Response to Planning application from Hertfordshire County Council (T and CP GDP Order 2015)

District ref: 6/2021/0773/FULL
HCC ref: WH/6300/2021
HCC received: 24 March 2021
Area manager: Matthew Armstrong
Case officer: Paul Marshall

1 MAYNARD PLACE CUFFLEY POTTERS BAR EN6 4JA

The erection of a one storey roof extension to create 6 no. flats including 3 x 1 bed and 3 x 2 bed flats, with associated parking and cycle and refuse provision

DRAWING NUMBER: 1254.01.PA2.100
REV:
ISSUED BY: CF

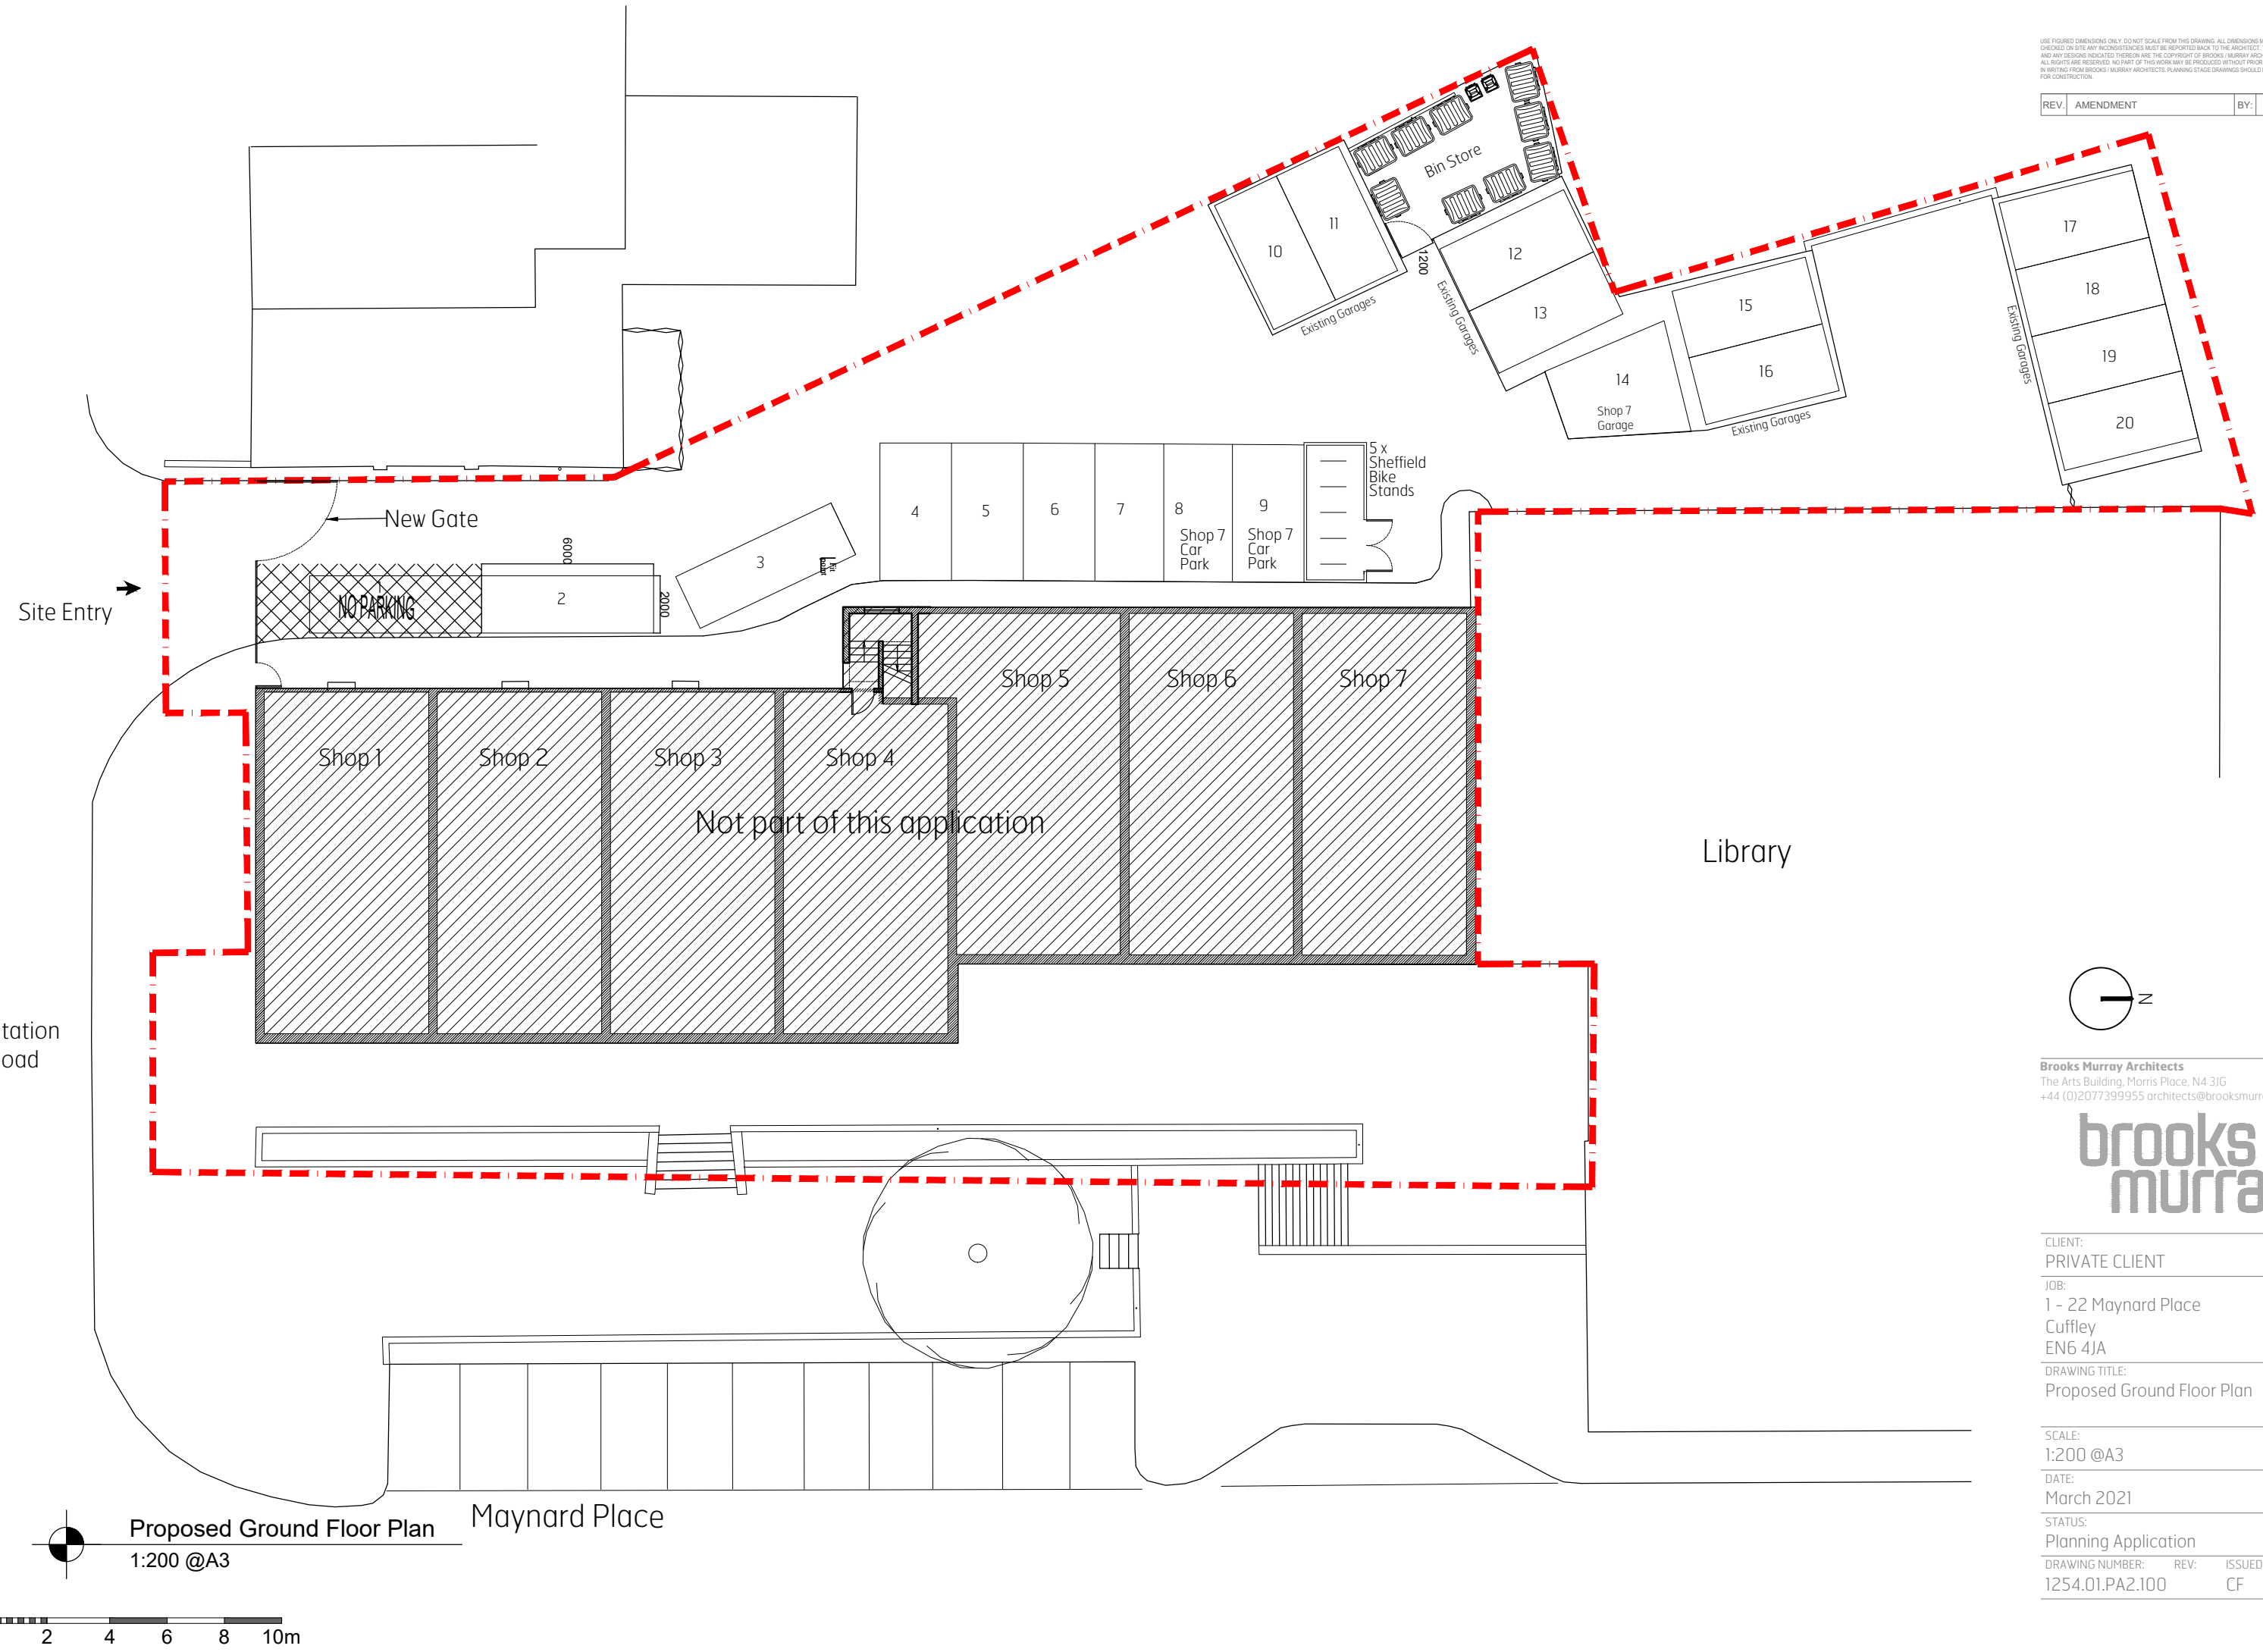
Drawing 1254.01.PA2.100 demonstrates a hatched passing area just behind the gates to the site to allow vehicles entering and leaving at the same time a place to pass. In previous discussions I suggested that parking bay 3 would have been a better option however, this is acceptable and allows for vehicles to enter and exit in a forward gear. Parking bays 2 and 3 at 6m x 2m accord with Manual

for Streets 8.4.39 for parallel parking. Parking bays 4-9 at 4.8 x 2.5m are in accordance with Manual for Streets 8.3.58, which states 'The recommended dimensions of off-street parking bays are that they are laid out as a rectangle at least 4.8 m long by 2.4 m wide for the vehicle'.

Drawing 1254.01.PA2.100 shows 5 Sheffield cycle stands adjacent to parking bay 9. The latest guidance is the 'Cycle Infrastructure Design' DfT Local Transport Note 1/20 (July 2020) which recommends for cycle parking storage should be 2m (1.8m is acceptable) in length by 0.5m space between cycles. Outside cycle parking should be covered and lockable. Please see Condition 1 above.

No new access is proposed for the site. Drawing 1254.01.PA2.100 shows gates at the point of the existing access. This is in-line with Roads in Hertfordshire: Highway Design Guide 3rd Edition Section 4 – Design Standards and Advice where gates should be set back a minimum of 5.5m to safely allow vehicles to draw off the carriageway.

Drawing 1254.01.PA2.100 demonstrates additional recycling capacity in the existing storage area. Collection by refuse operators remains the same.

CON1) Prior to the first occupation of the development hereby permitted (or Prior to the commencement of the use hereby permitted) the proposed access /onsite car and cycle parking / servicing / loading, unloading / turning /waiting area shall be laid out, demarcated, levelled, surfaced and drained in accordance with the approved plan and retained thereafter available for that specific use.

CON2) Prior to the first occupation of the development hereby permitted any access gate(s), bollard, chain or other means of obstruction shall be hung to open inwards, set back, and thereafter retained a minimum distance of a minimum of 5.5 metres from the edge of the highway.
